Rezoning Petition Review

From: Doug Lozner

Date of Review: October 29, 2020 ***Revised November 30, 2020***

Rezoning Petition #: 20-134

RZ-1.0

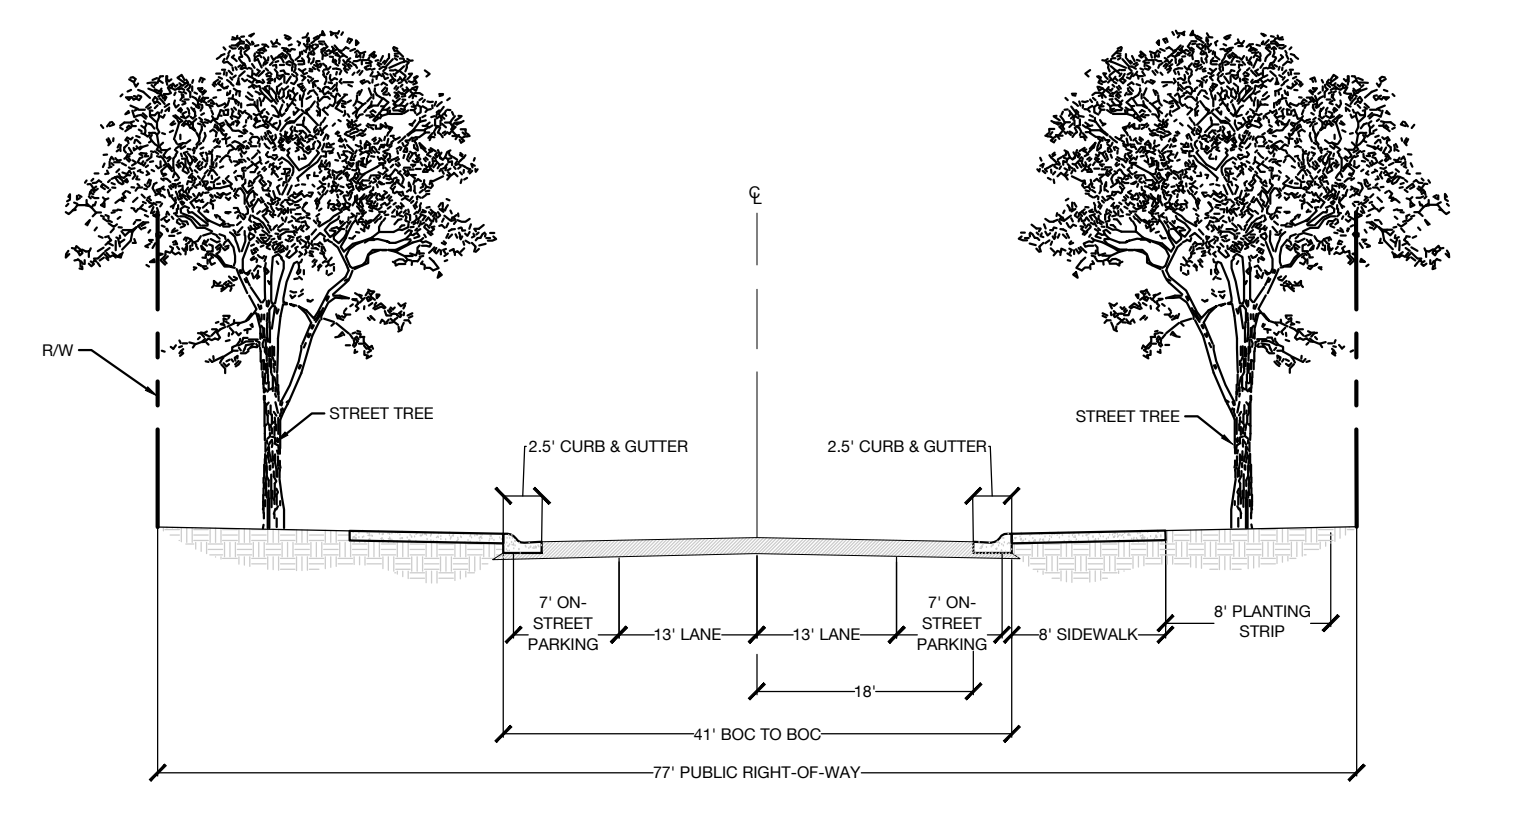
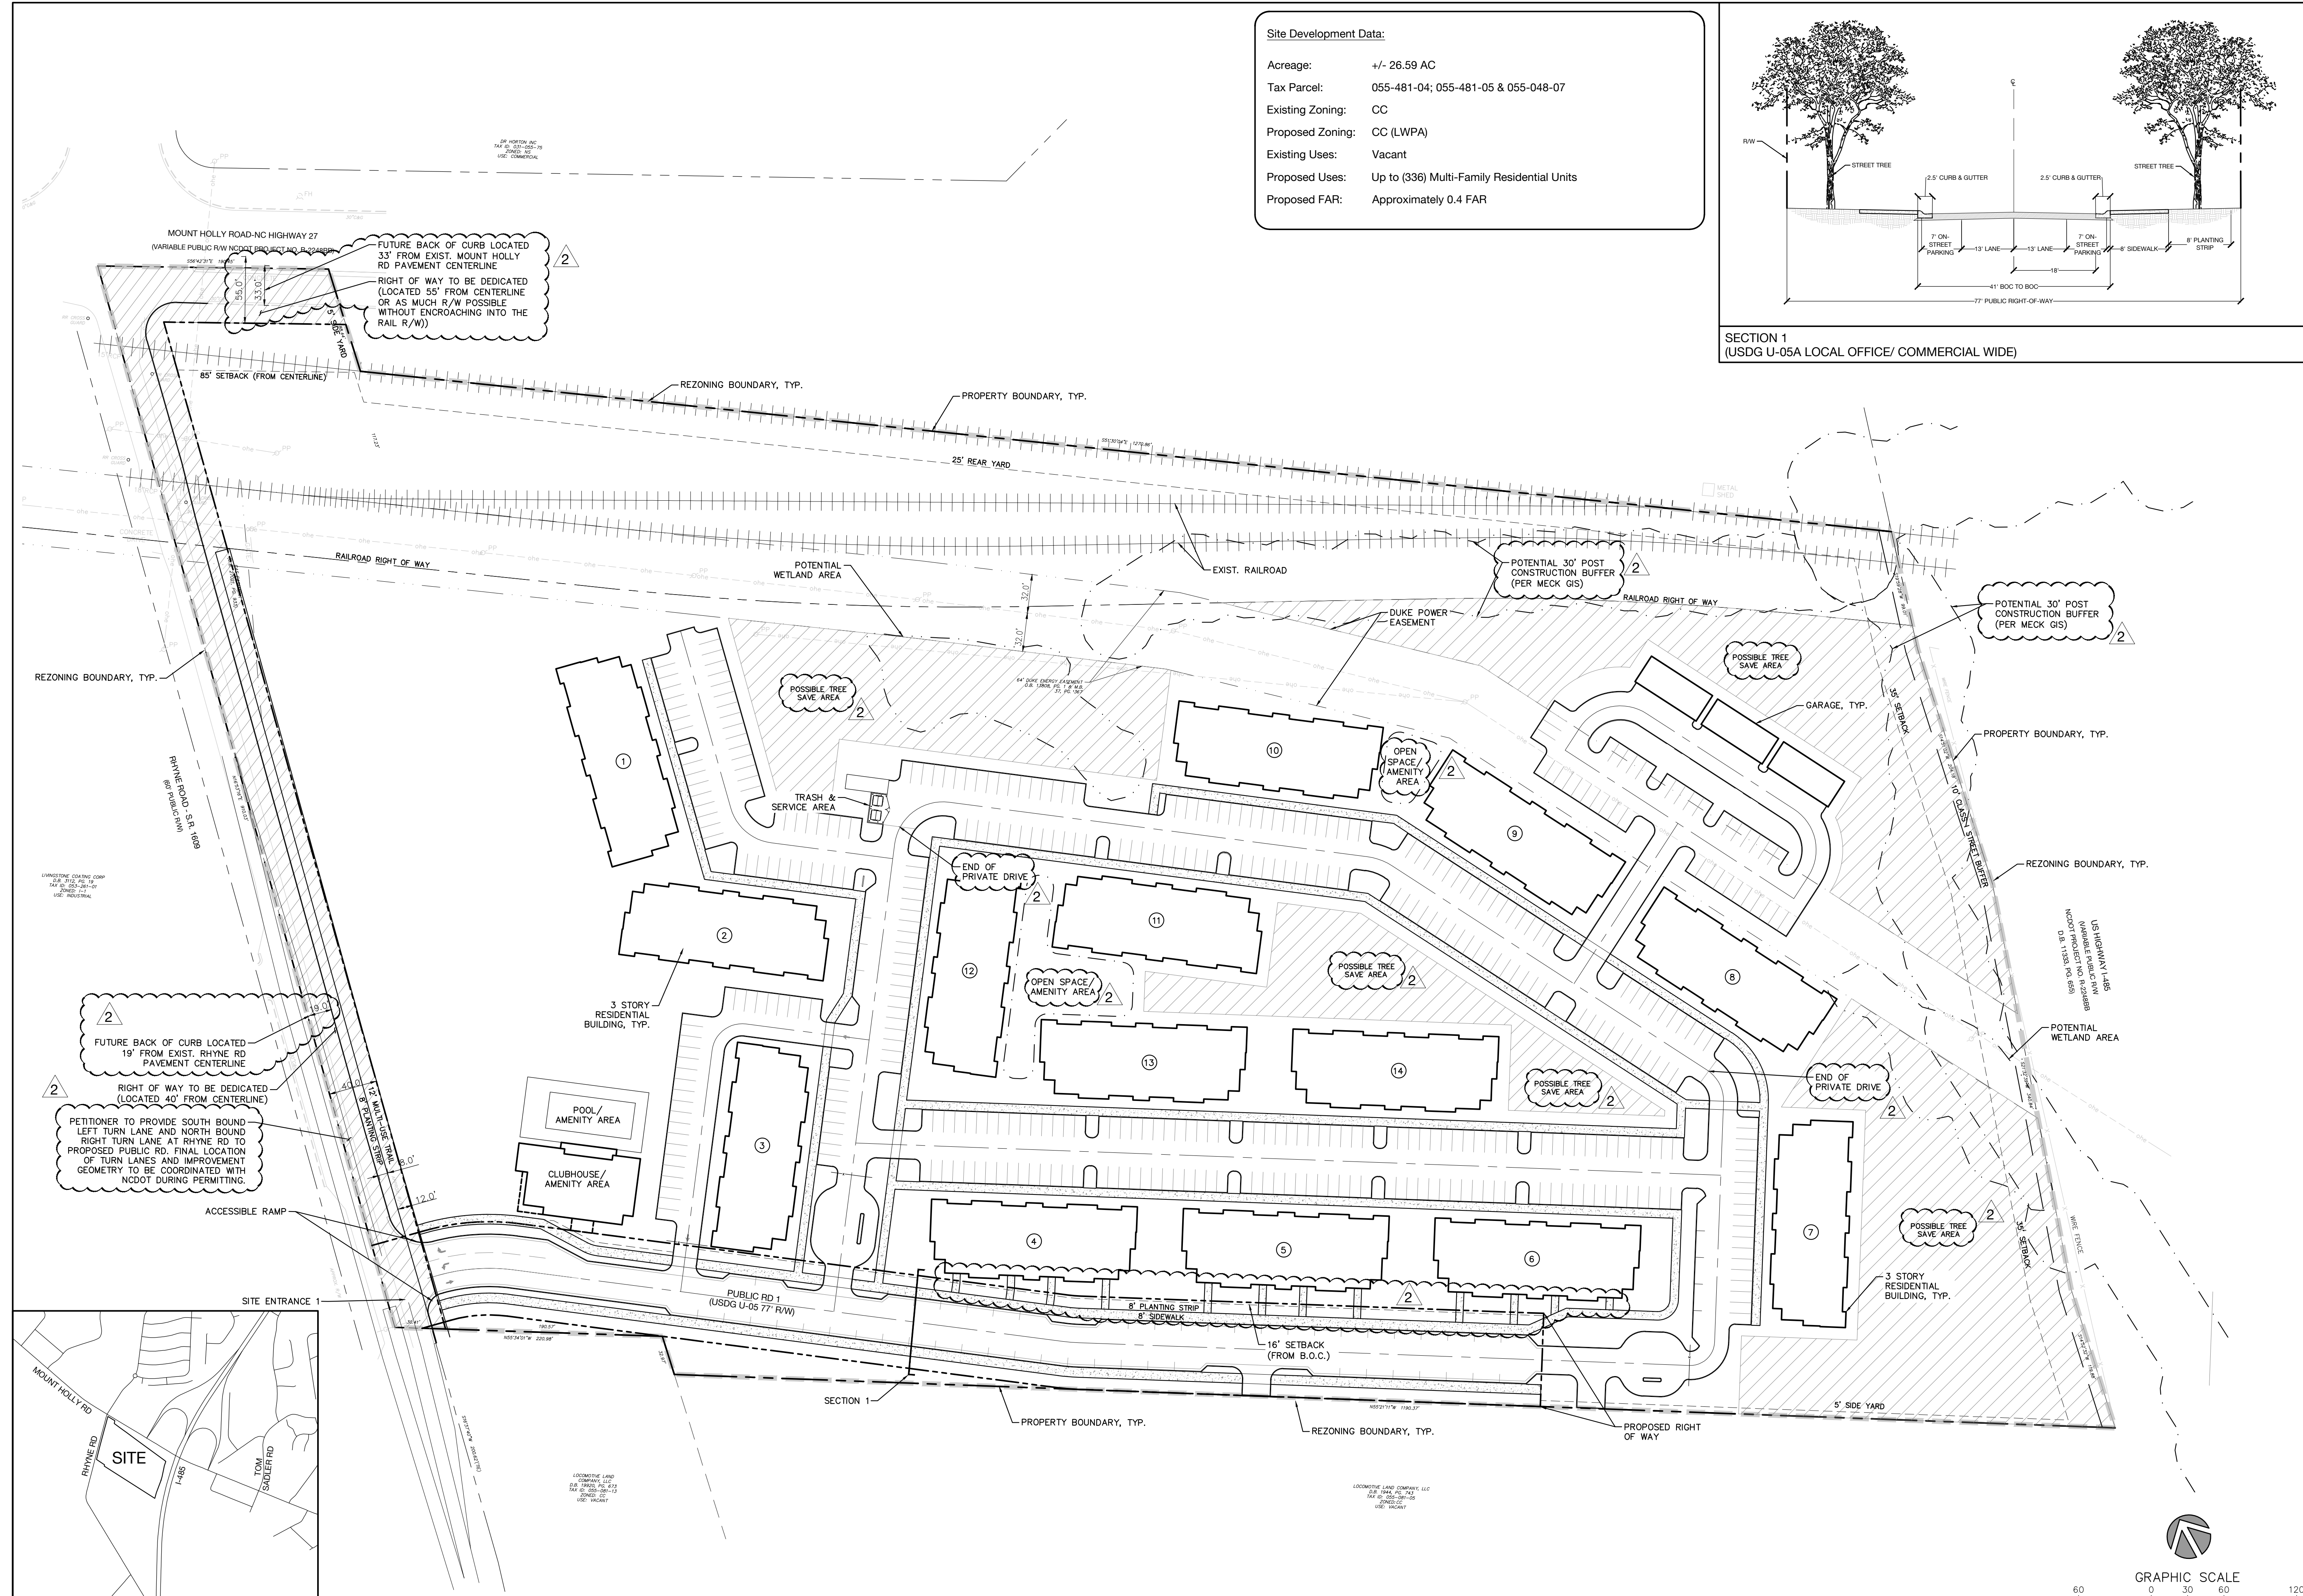
Due to revisions (11/30/20): City of Charlotte GIS data indicates a 30-ft PCSO buffer across the northern and eastern property lines of the site. Please show and label *Potential 30-ft PCSO Buffer* on the site plan. Any increase of impervious area within such buffers may not be allowed and is not approved with the rezoning process. Stream Delineation Reports are subject to review and approval by Charlotte Storm Water Services. Please include the following note under Environmental Features: *“Development within any SWIM/PCSO Buffer shall be coordinated with and subject to approval by Charlotte-Mecklenburg Storm Water Services and mitigated if required by City ordinance. Petitioner acknowledges intermittent/perennial stream delineation reports are subject to review and approval upon submission of development plans for permitting and are not approved with rezoning decisions.”*
